**PROPOSED MIXED USE DEVELOPMENT
WOODSTOCK EAST, OXFORDSHIRE
APPLICATION REF. - 14/02004/HYBRID**

TRANSPORT ASSESSMENT APPRAISAL NOTE

This Note has been prepared by Glanville Consultants on behalf of Woodstock Town Council to summarise preliminary findings of a review of the Transport Assessment (TA) prepared by David Tucker Associates (ref. SJT/NES 15291-02j) dated 28 November 2014. The TA accompanies a part outline part full application for mixed use development on approximately 50 hectares of land east of Woodstock, Oxfordshire.

JOB TITLE		Woodstock East		CLIENT		Pye Homes & Vanbrugh Trust	
DRAWING TITLE							
Proposed 45m Roundabout Access							
SCALE	DRAWN BY	DATE	DRAWING No	REVISION			
1:1000@A3	BP	Sept14	15291-21	A

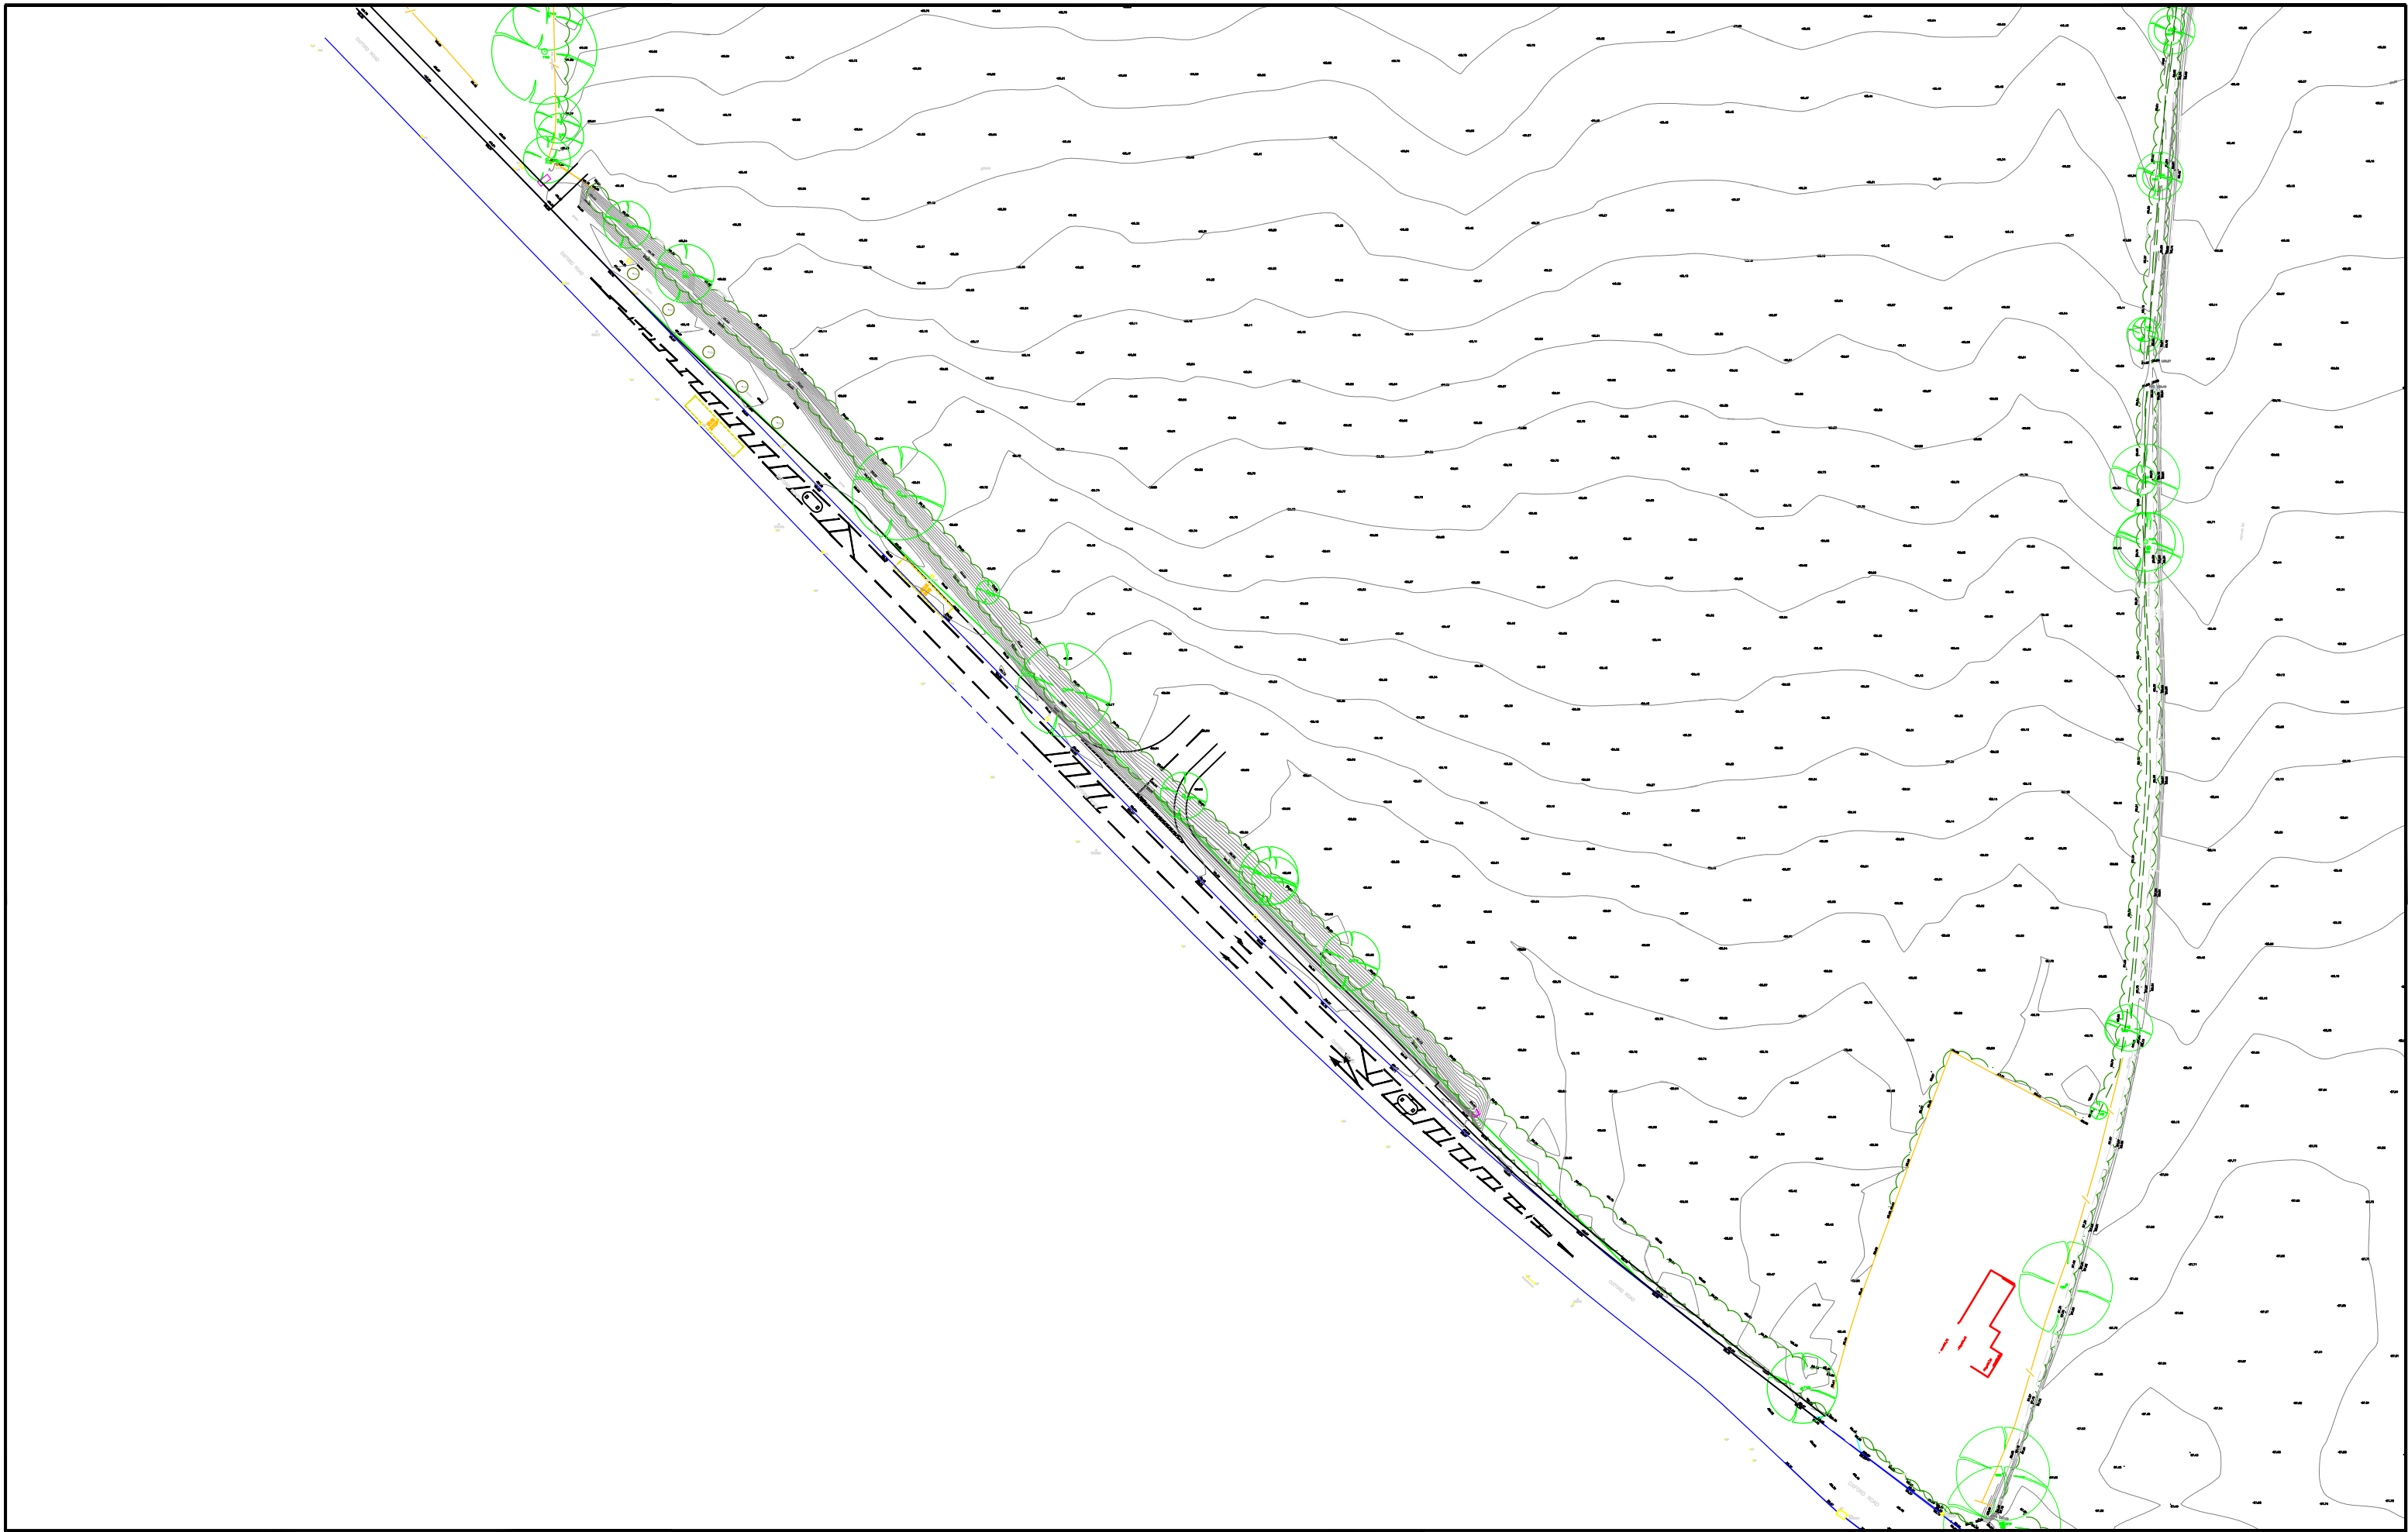
8. The proposed new main site access / A4095 Upper Campsfield Road roundabout design does not appear to conform to DMRB standards in terms of ICD / island ratio. Also, the A4095 approach road alignments are considered poor, particularly as site land appears available to improve this element of the design.

Proposed site access junctions should be further considered in line with relevant DMRB guidance to ensure safe and viable access from the strategic highway can be provided.

JOB TITLE		Woodstock East		CLIENT		Pye Homes Vanbrugh Trust	
DRAWING TITLE							
Proposed A44 site access							
SCALE	DRAWN BY	DATE	DRAWING No	REVISION			
1:1000@A3	BP	Sept14	15291-22	B

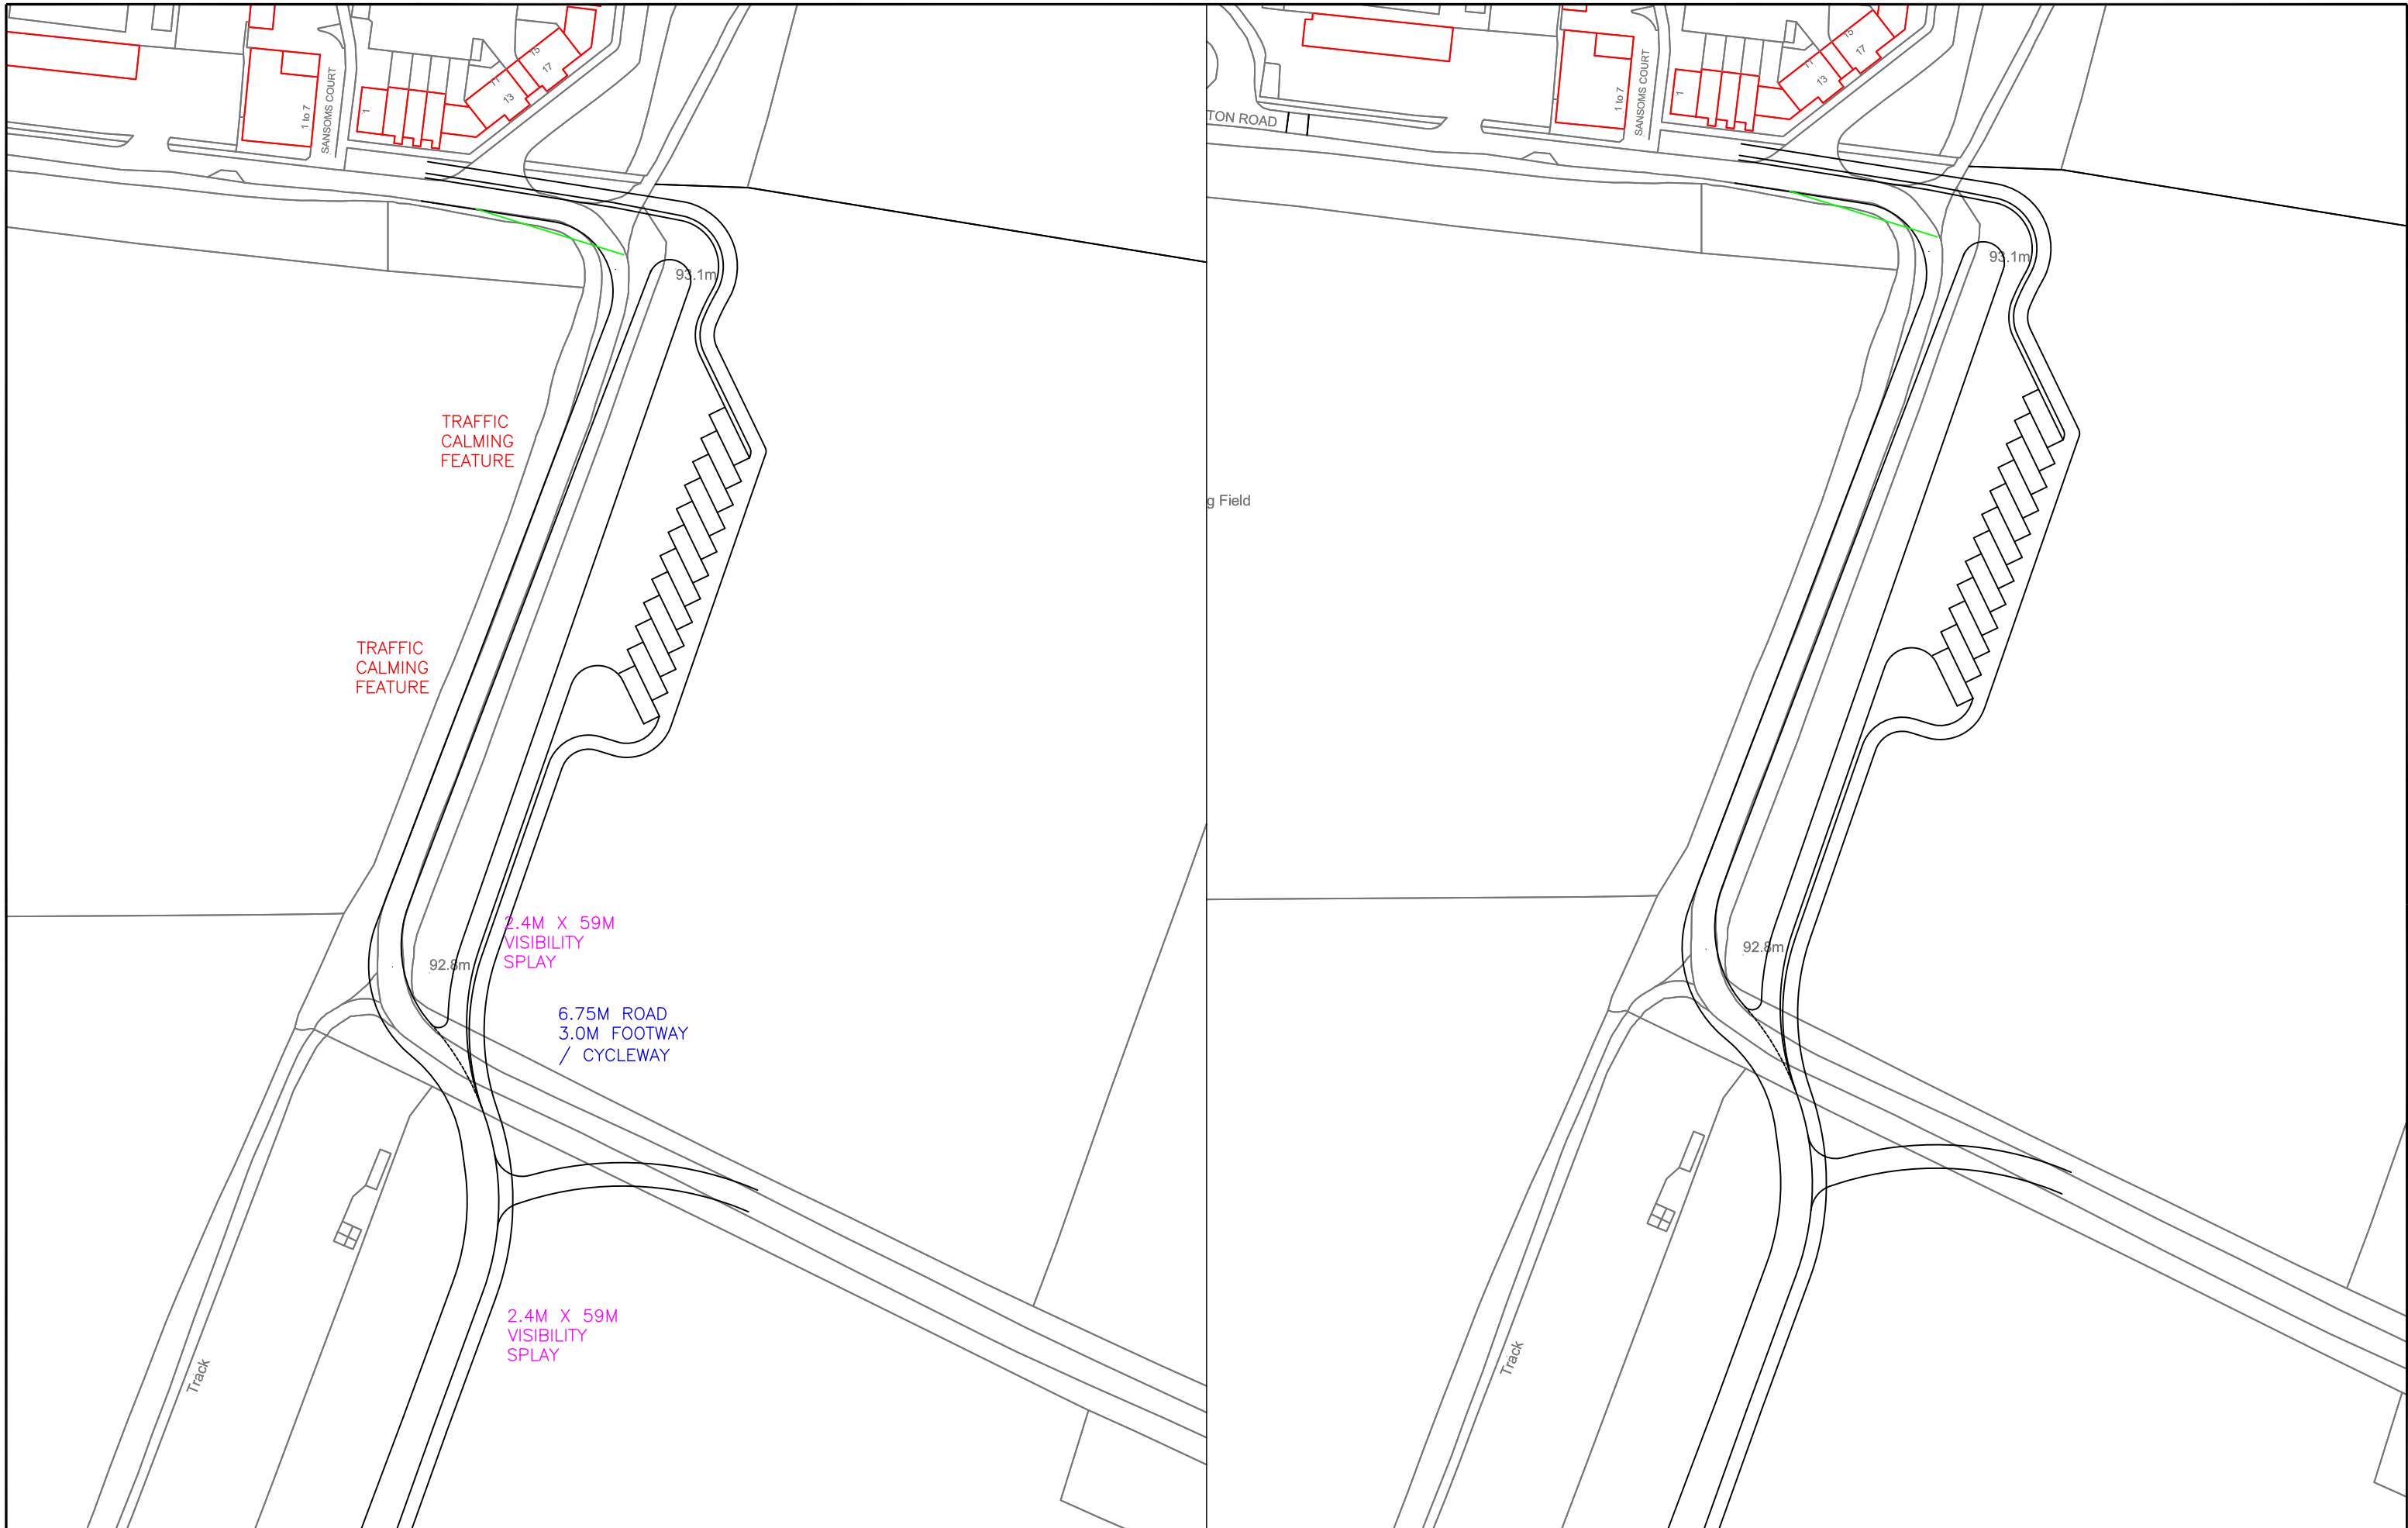
5. A copy of drawing P100 showing the layout of the detailed application element of the scheme shows the proposed new right-turn lane junction with the A44. The siting of the new access relative to the existing private access opposite appears too close to accord with DMRB guidance which advises a minimum distance of 50m between two minor roads. Have the principles of this arrangement been agreed with OCC together with appraisal through a Stage 1 Road Safety Audit?
